Road Infrastructure Design Report

Alterations to Shoreline GA01 Lands at Baldoye

Stapolin Growth Area 1, Baldoye, Co. Dublin

BS 1192 FIELD **BD-CSC-ZZ-XX-RP-C-0107-P3**

Drawing file: Engineering / BD-CSC-ZZ-XX-DR-C-0017_Proposed Bus Route.pdf

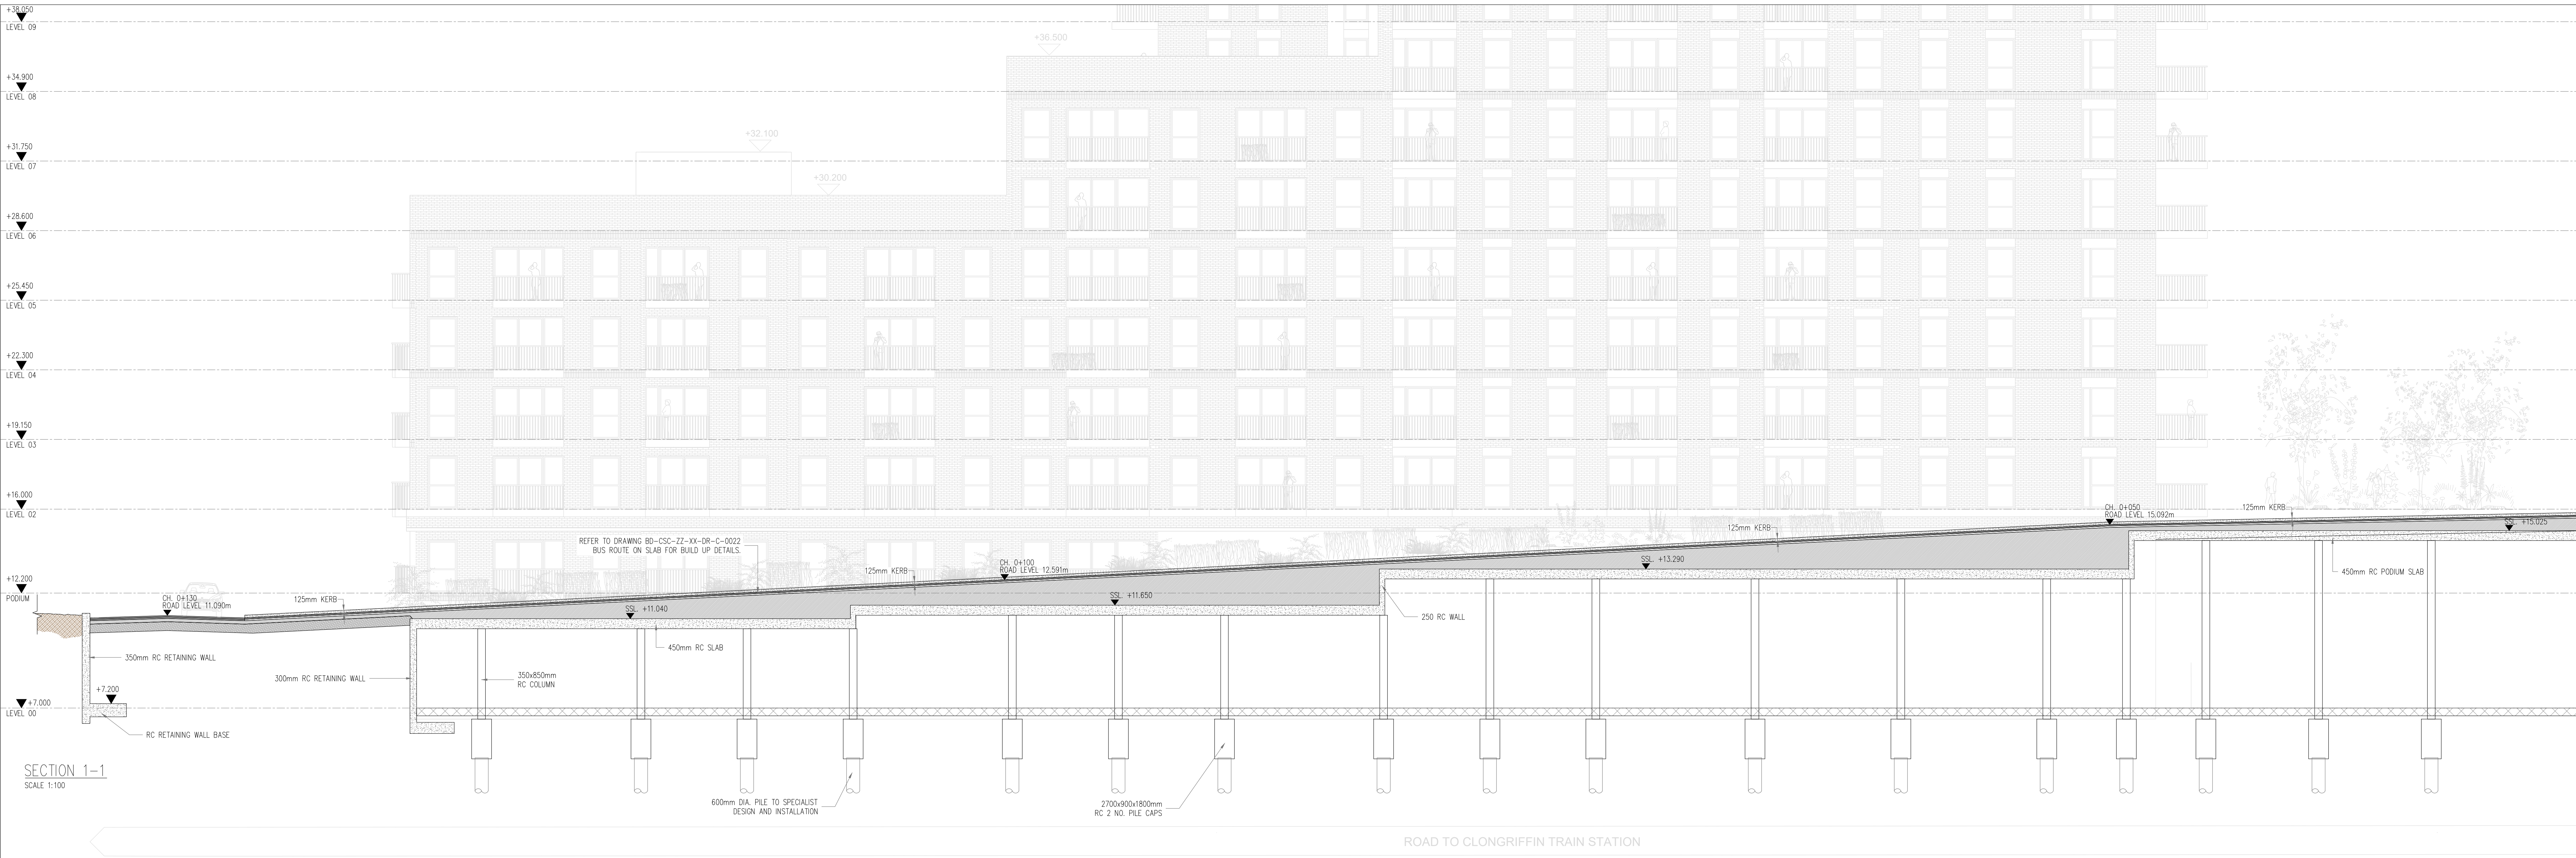
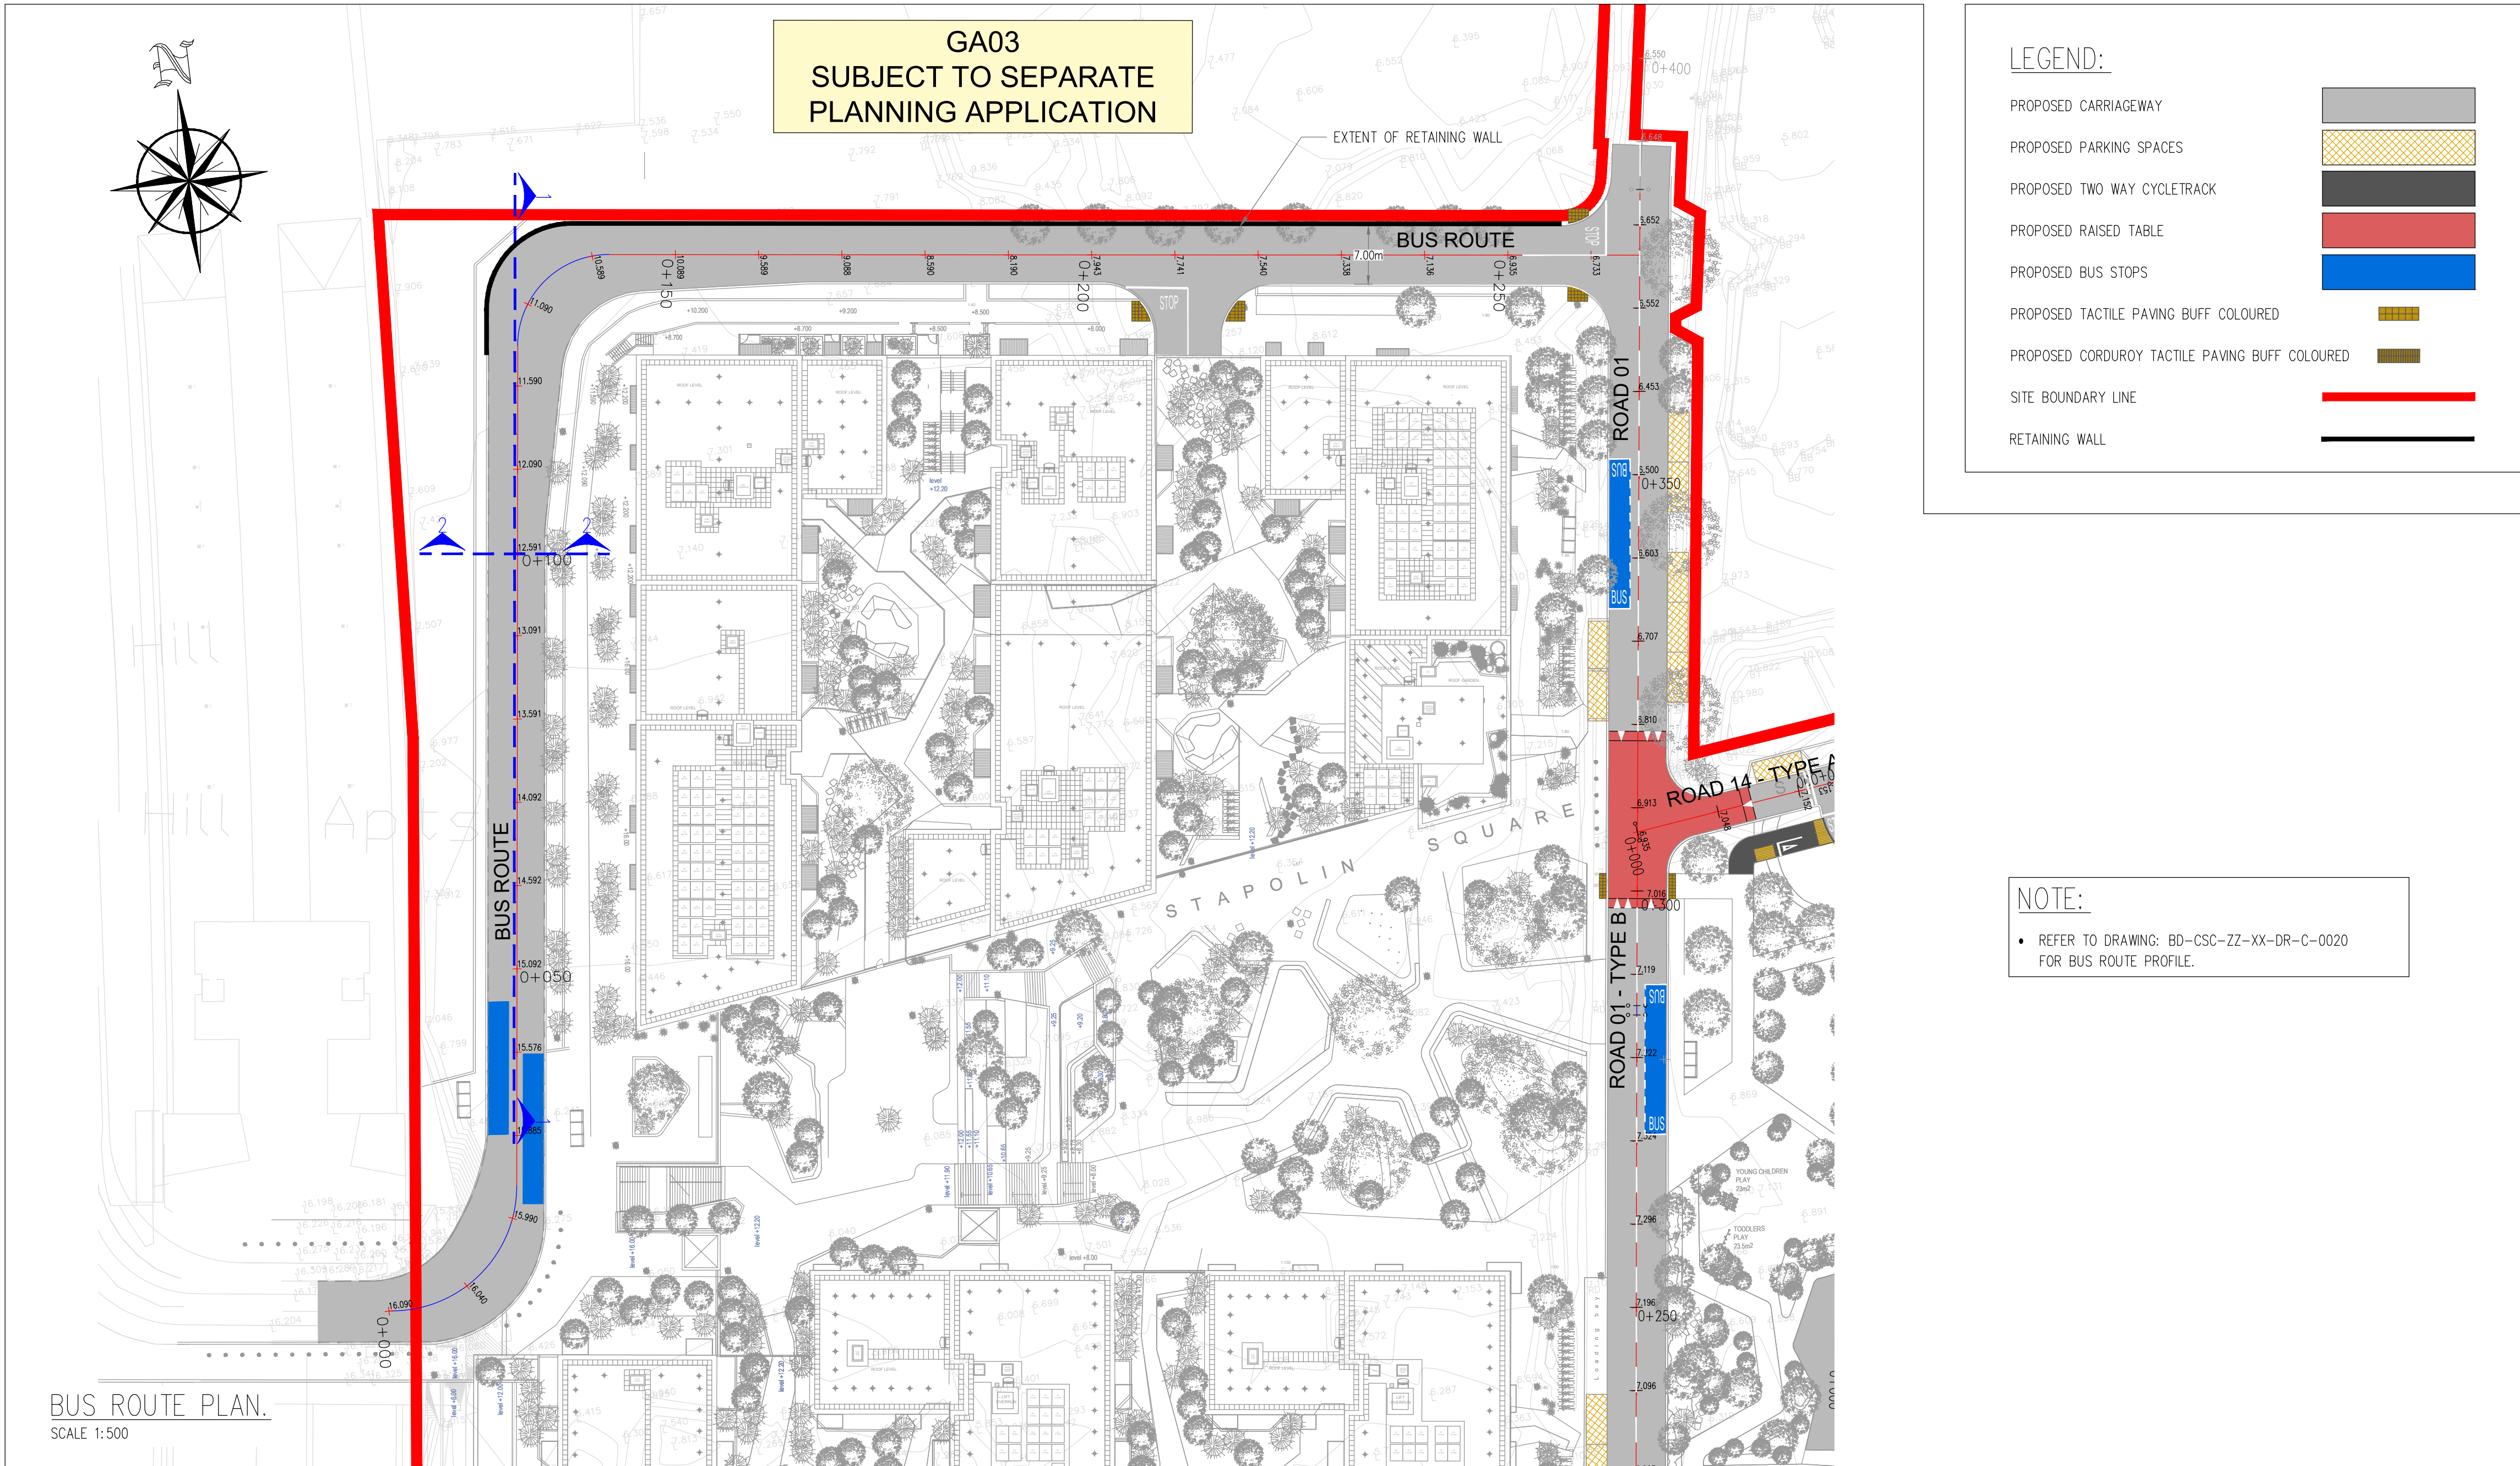
“The applicant has provided insufficient information within the current submission with regard to the construction details of the ramp which is to connect to Clongriffin Station. Information is required relating to the build-up and construction methods need to be provided. This should be requested to form part of any formal application.”

Refer to CS Consulting drawing BD-CSC-ZZ-XX-DR-C-0017 for structural and road build-up details of the proposed bus ramp to Clongriffin Station. The construction methodology and scheduling for this ramp will be discussed in detail with both Iarnród Éireann and Dublin Bus prior to the commencement of works, as described in the accompanying Construction Management Plan.
